## MEMORANDUM

**TO:** Nell Donaldson, Planner  
**FROM:** Lauren Swett, PE  
**DATE:** September 21, 2016  
**RE:** 30 Merrill Street, Level III Site Plan Application

Woodard & Curran has reviewed the Site Plan Application for the proposed development located at 30 Merrill Street in Portland, Maine. The project involves the construction of a four story residential building with parking in the rear of the lot.

PERVIOUS PAVEMENT SECTION DETAIL
NOT TO SCALE

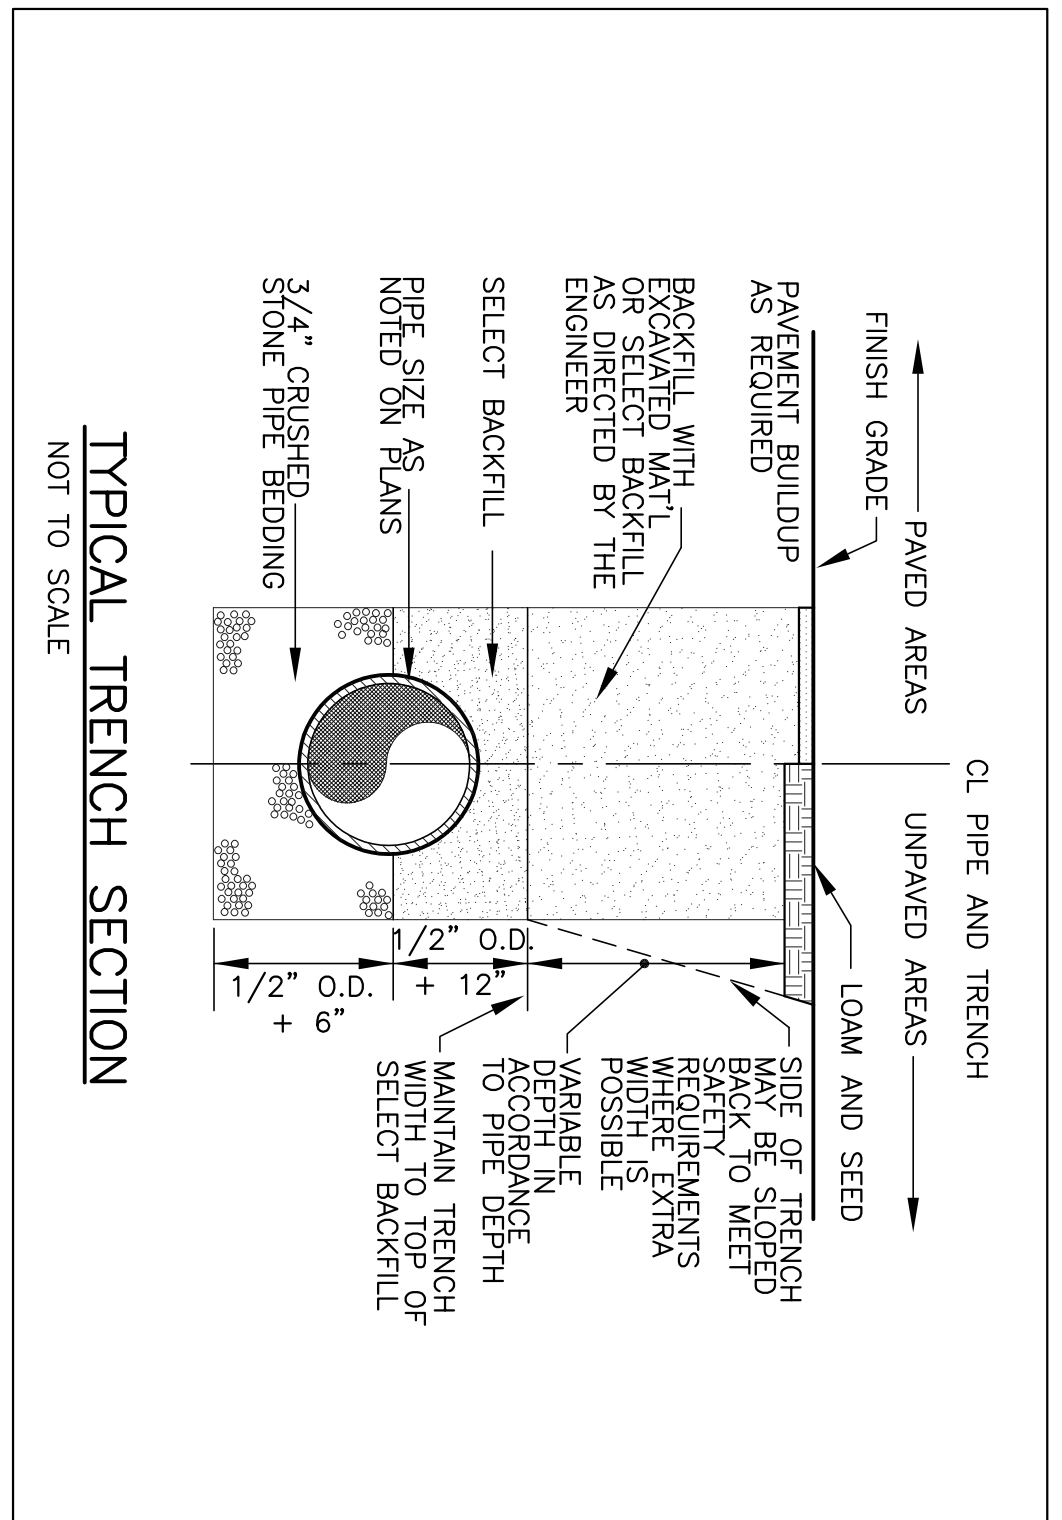
- The Applicant has noted in their response that during construction, the site conditions (bedrock/groundwater) will determine the need for a liner system for the pervious pavers. The Applicant should provide this as a note on the detail for the pervious paver system on sheet C4.
